Horsham  
District  
Council

# Gatwick Airport Northern Runway

National Infrastructure Project: TR020005

Principal Areas of Disagreement Summary Statement  
Version 3 (clean version)

Title:
Ordnance Survey Base Map Identifying Category 3 and Noise Insulation Scheme Boundary - Sheet 1 of 4

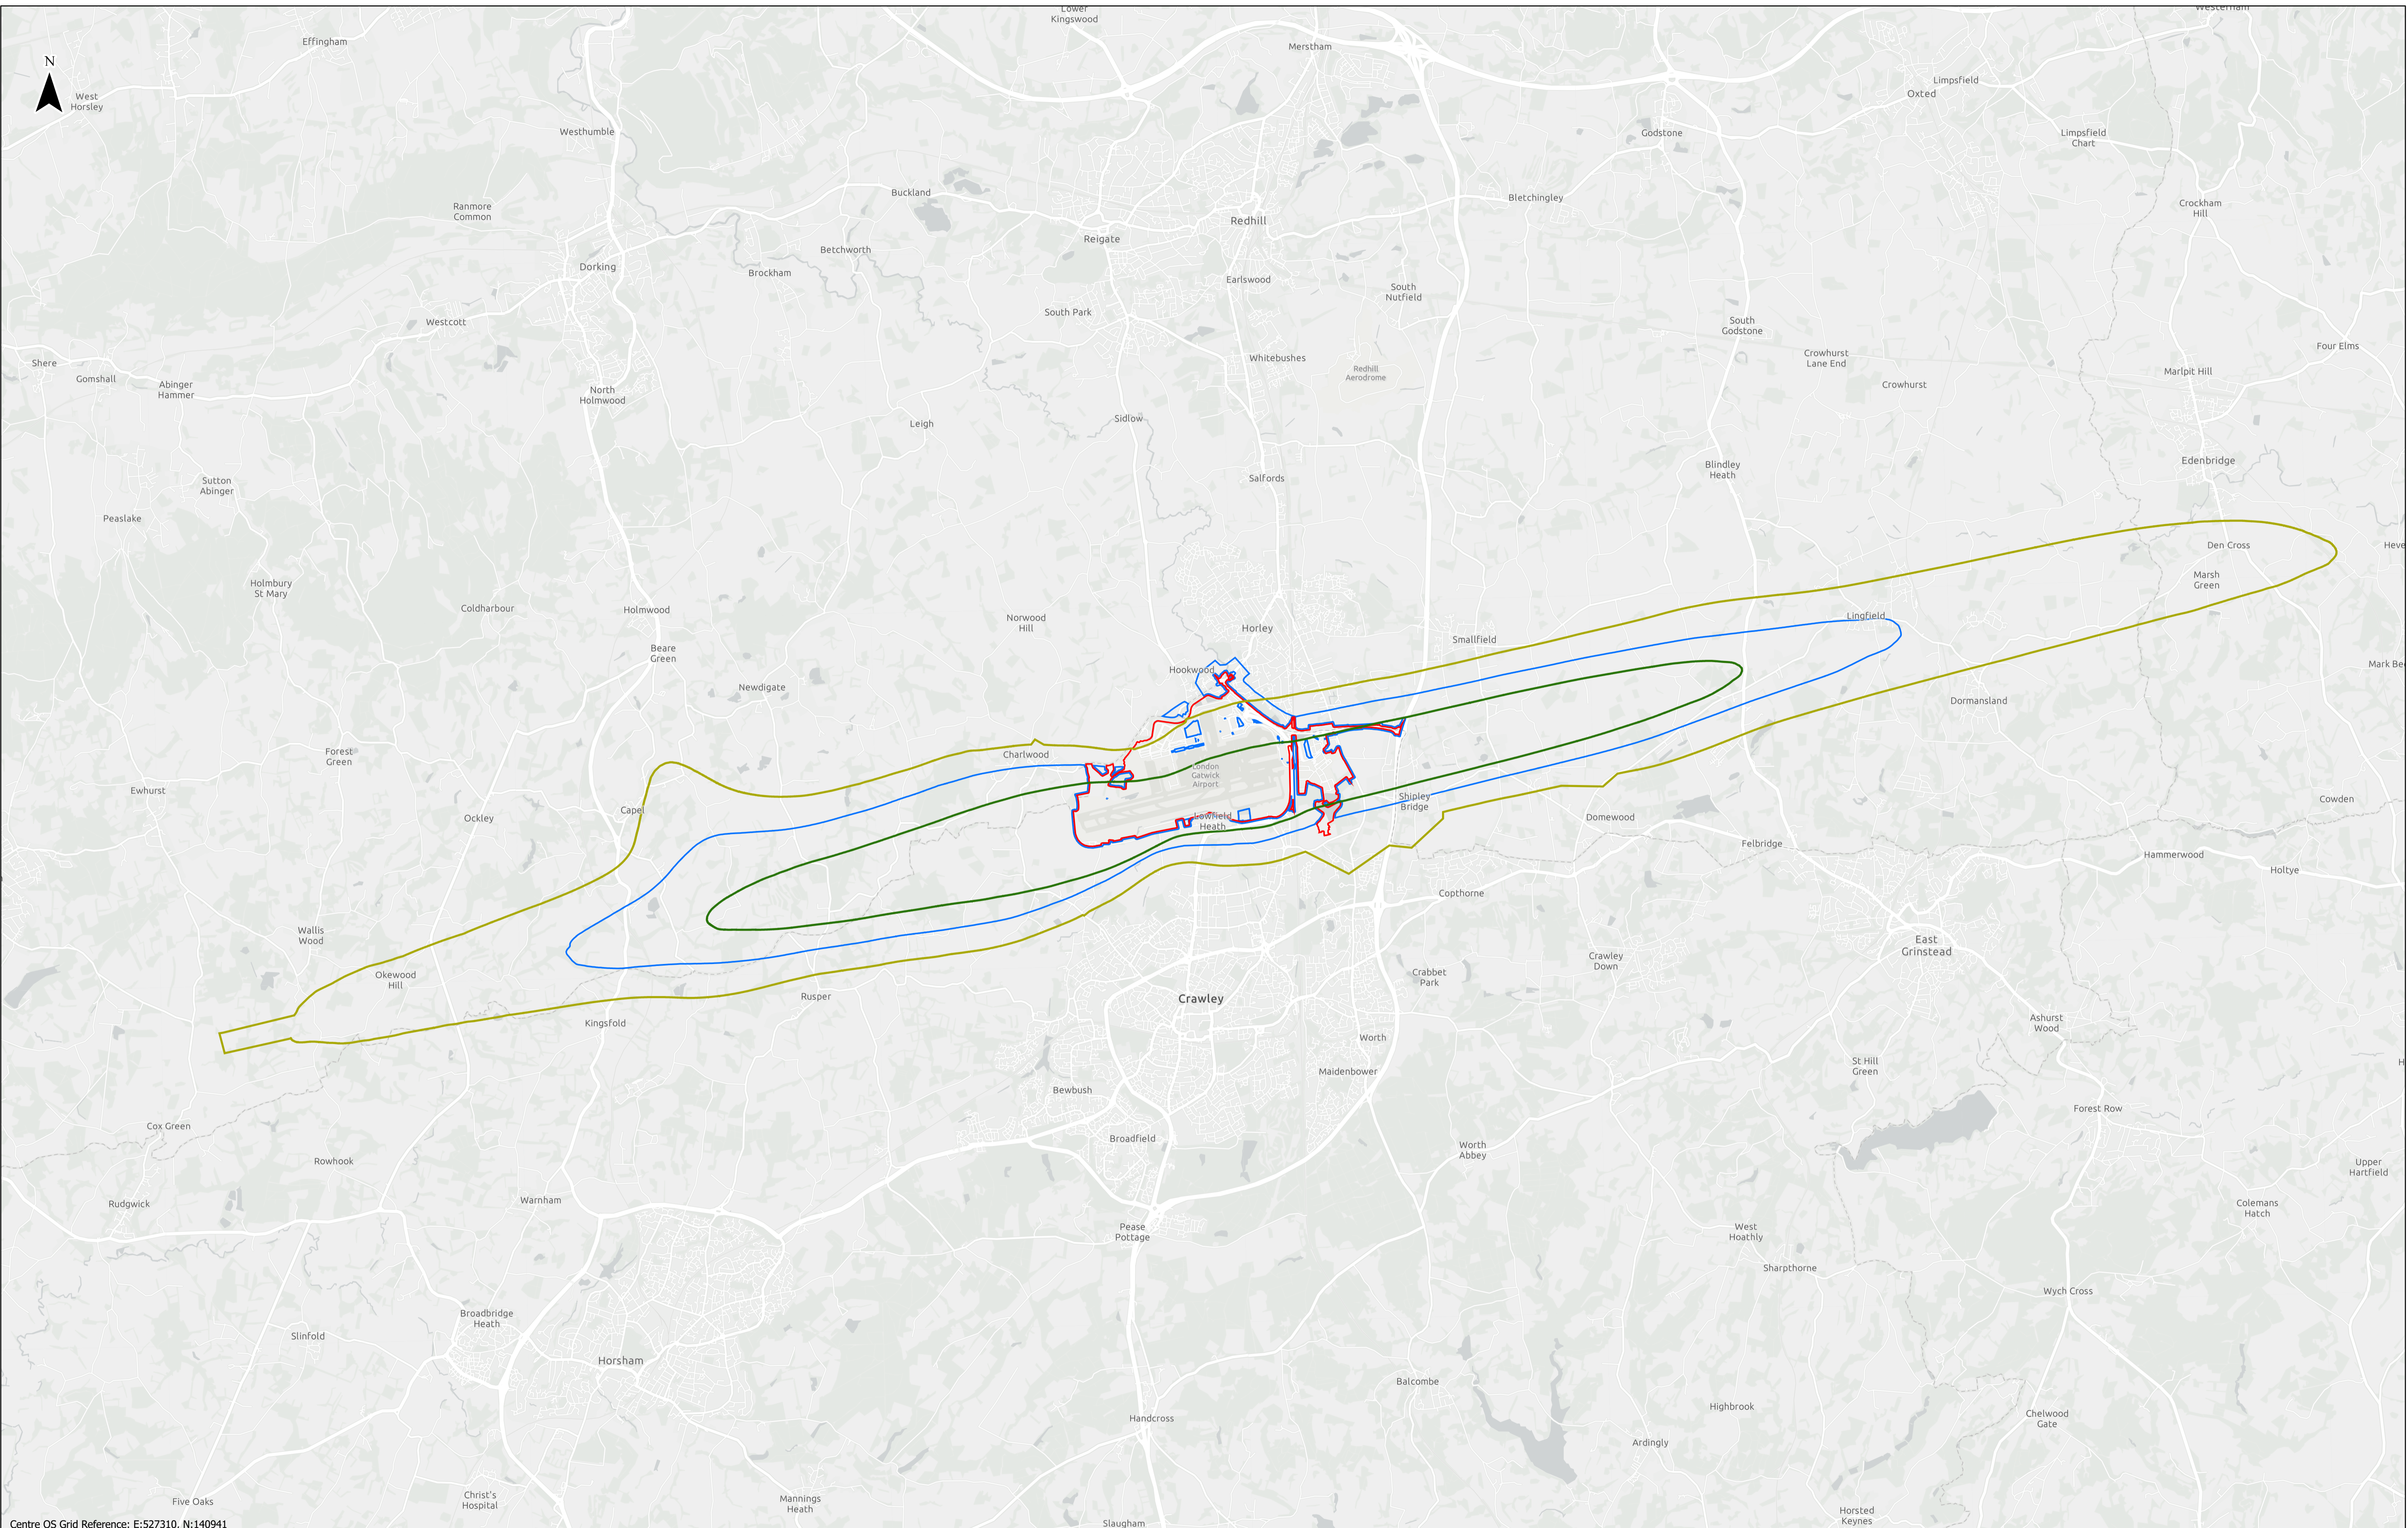
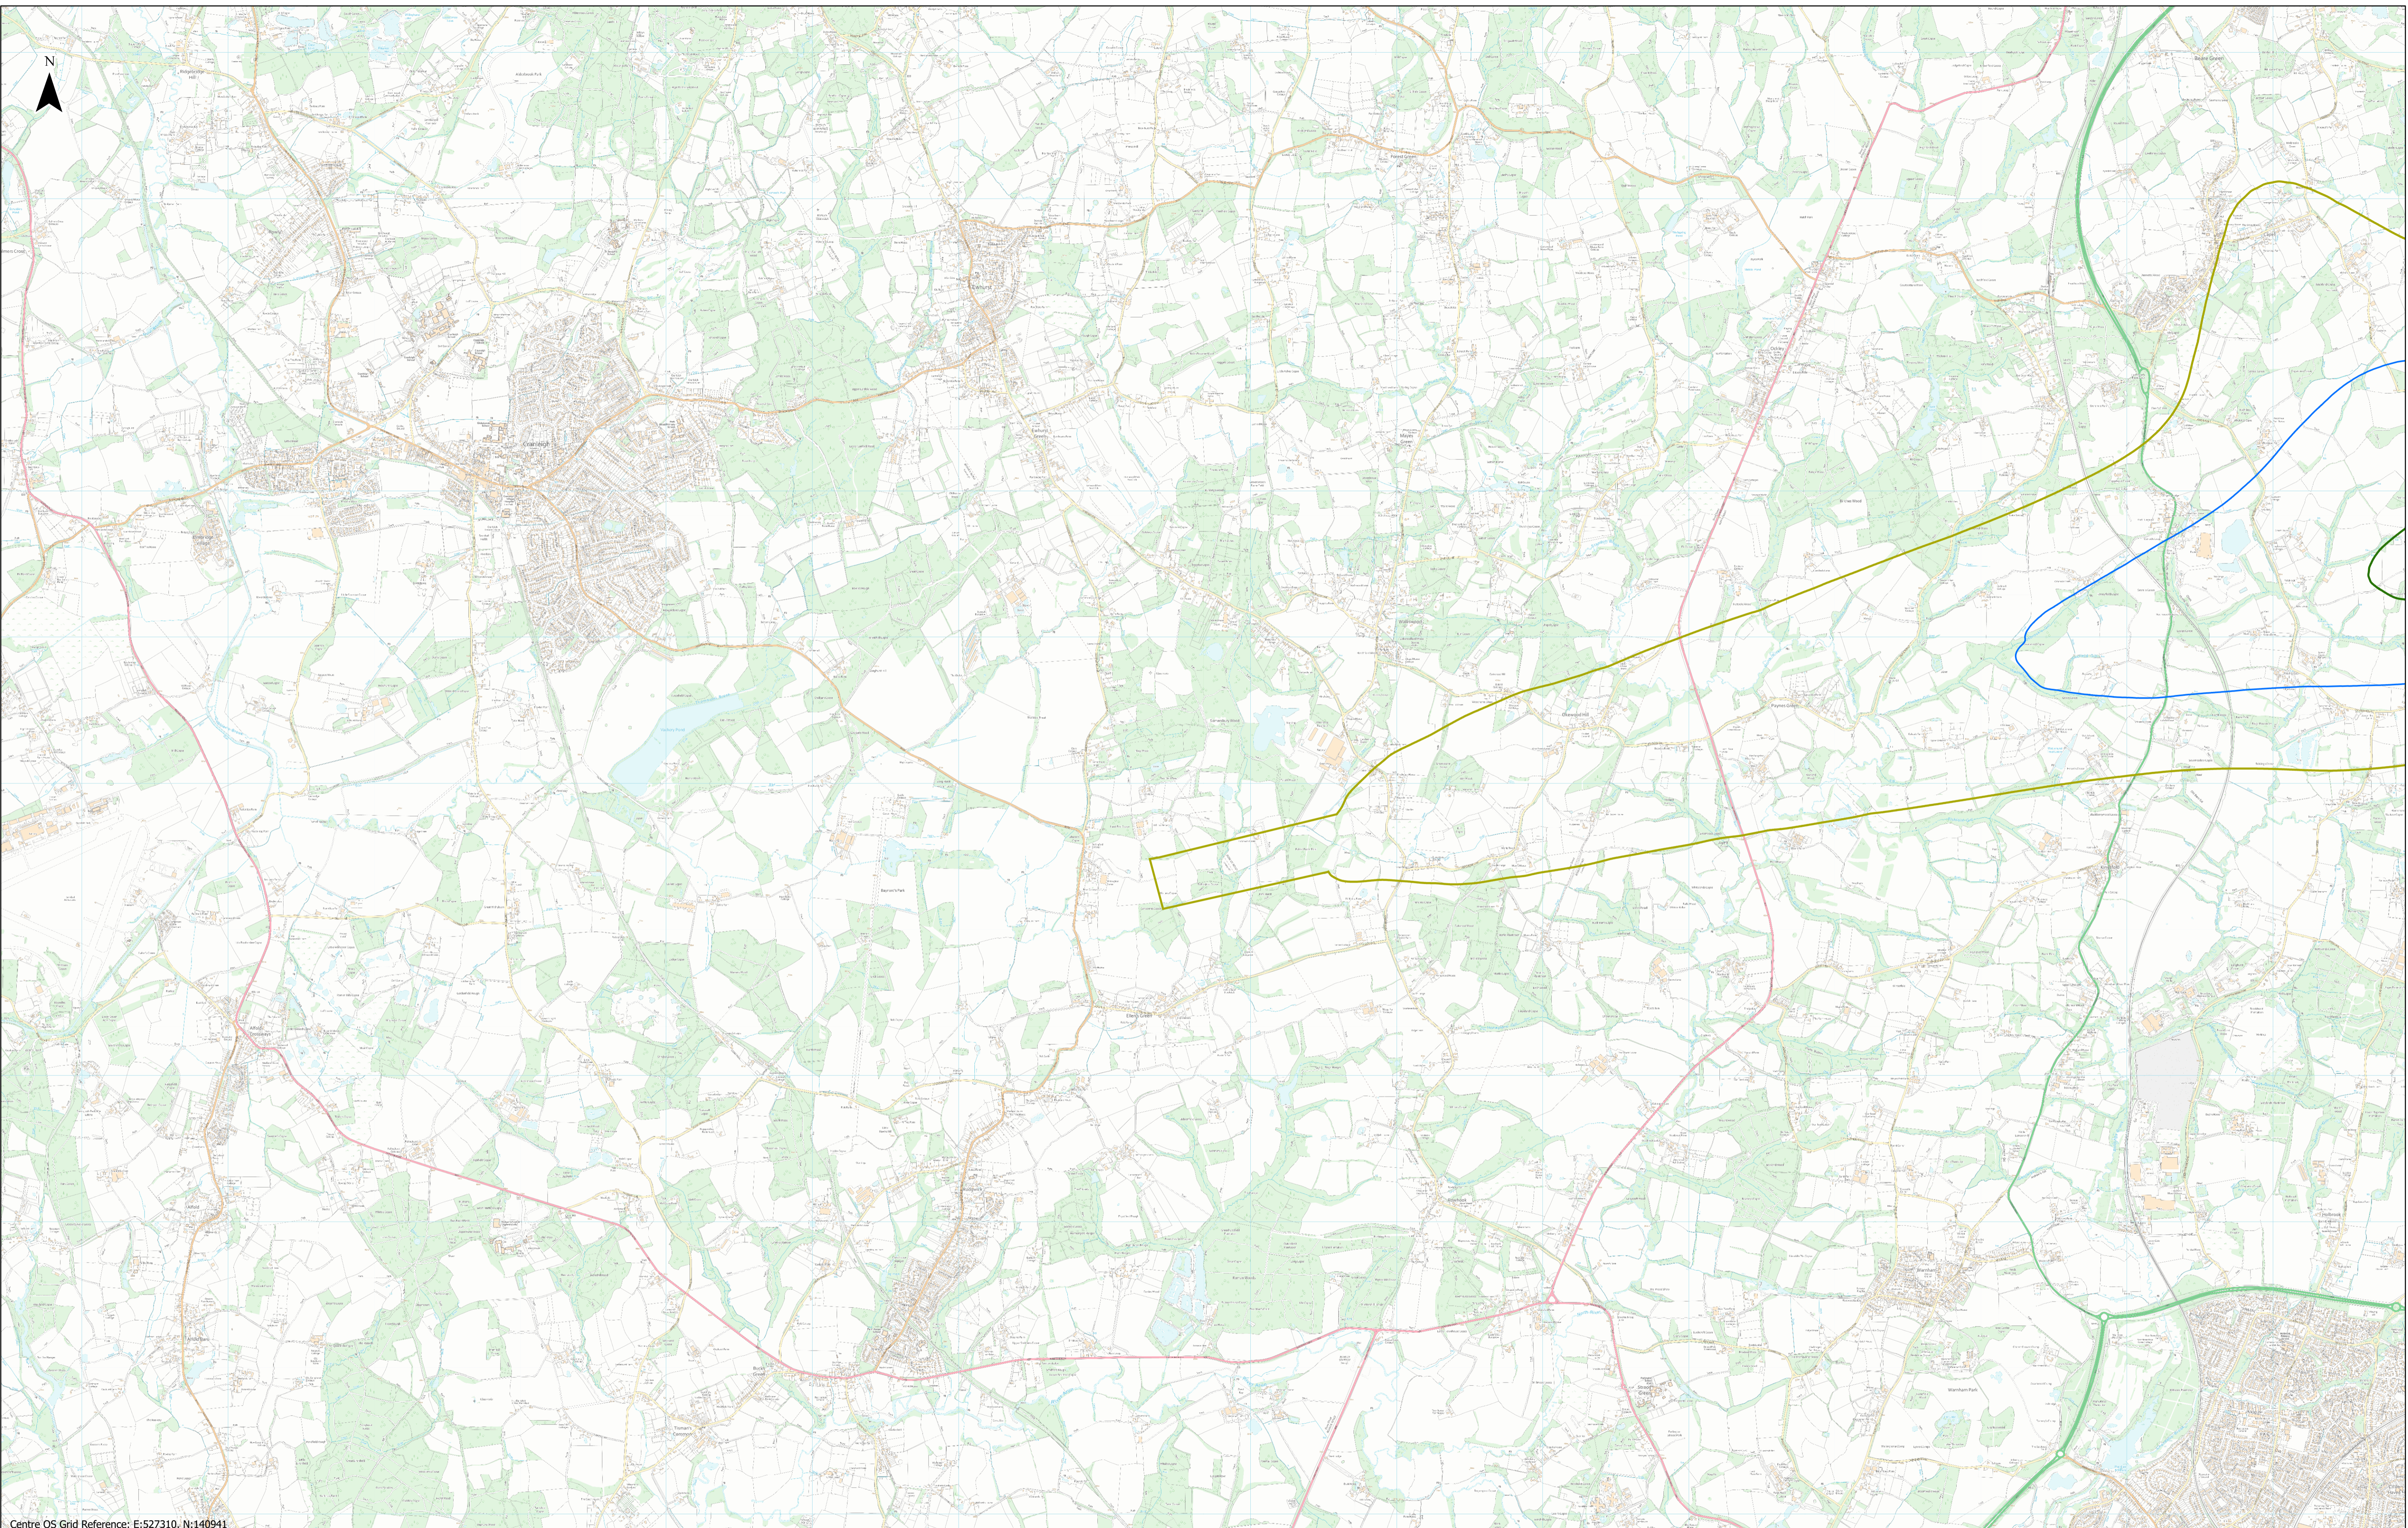
4.9	Noise Insulation Scheme	The noise insulation scheme is not sufficient to protect those who will suffer adverse effects of noise and deal	The Applicant will need to improve the offering based on consideration of a wider range of	Uncertain
